NSW RURAL FIRE SERVICE

Your reference: SSD-22191322
Our reference: DA20210530002237-EIS & DA
Exhibition-1

Date: Tuesday 31 August 2021

**State Significant Development - Warehouse or Distribution Centre
Request for comments - exhibited Environmental Impact Statement (EIS)
2 Aldington Road Kempas Creek NSW 2178, 26//DP1269741**

## Landscape Sketch Plan - Lot 4E

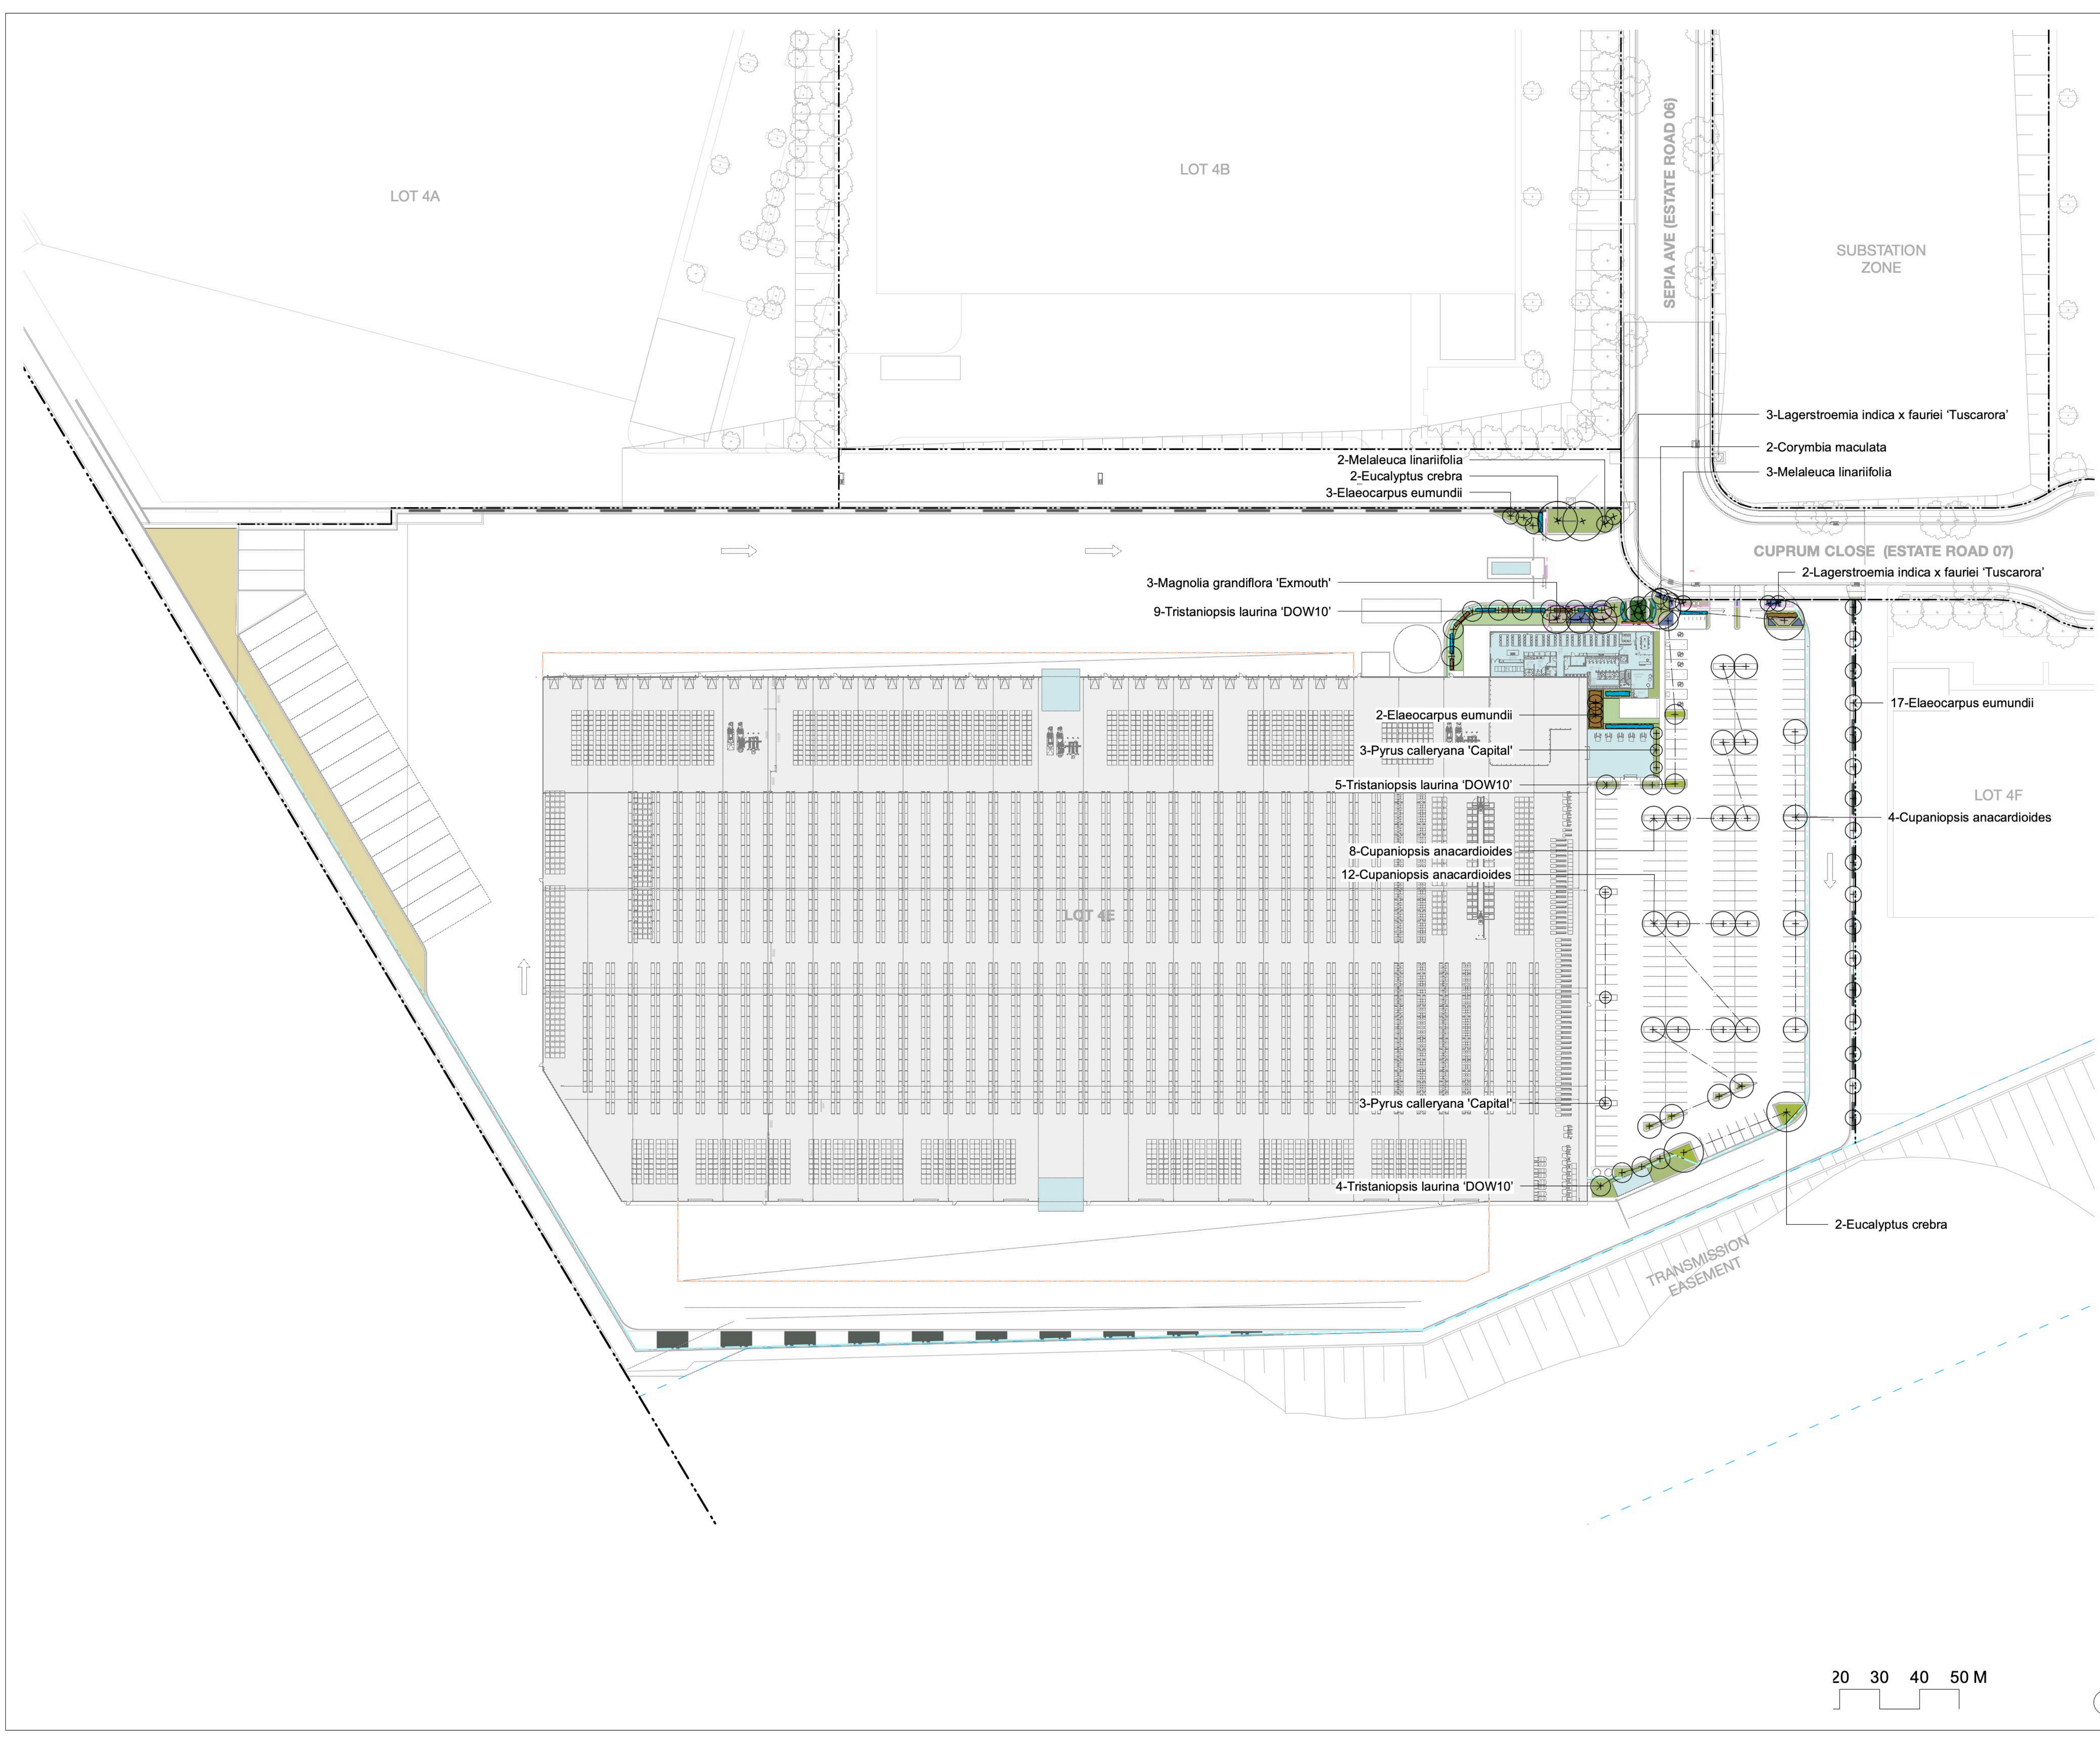
5. Landscaping within the entire subject development site must comply with Appendix 4 of *Planning for Bush Fire Protection 2019*. In this regard, the following principles are to be incorporated:

- A minimum 1 metre wide area, suitable for pedestrian traffic, must be provided around the immediate curtilage of the building;
- Planting is limited in the immediate vicinity of the building;

- Planting does not provide a continuous canopy to the building (i.e. trees or shrubs are isolated or located in small clusters);
- Landscape species are chosen to ensure tree canopy cover is less than 15% (IPA) at maturity and trees do no touch or overhang buildings;

- Avoid species with rough fibrous bark, or which retain/shed bark in long strips or retain dead material in their canopies;
- Use smooth bark species of trees species which generally do not spread fire up the bark into the crown;

- Avoid planting of deciduous species that may increase fuel at surface/ ground level (i.e. leaf litter);
- Avoid climbing species to walls and pergolas;

- Locate combustible materials such as woodchips/mulch, flammable fuel stores away from the building;
- Locate combustible structures such as garden sheds, pergolas and materials such as timber garden furniture away from the building; and

- Low flammability vegetation species are used.
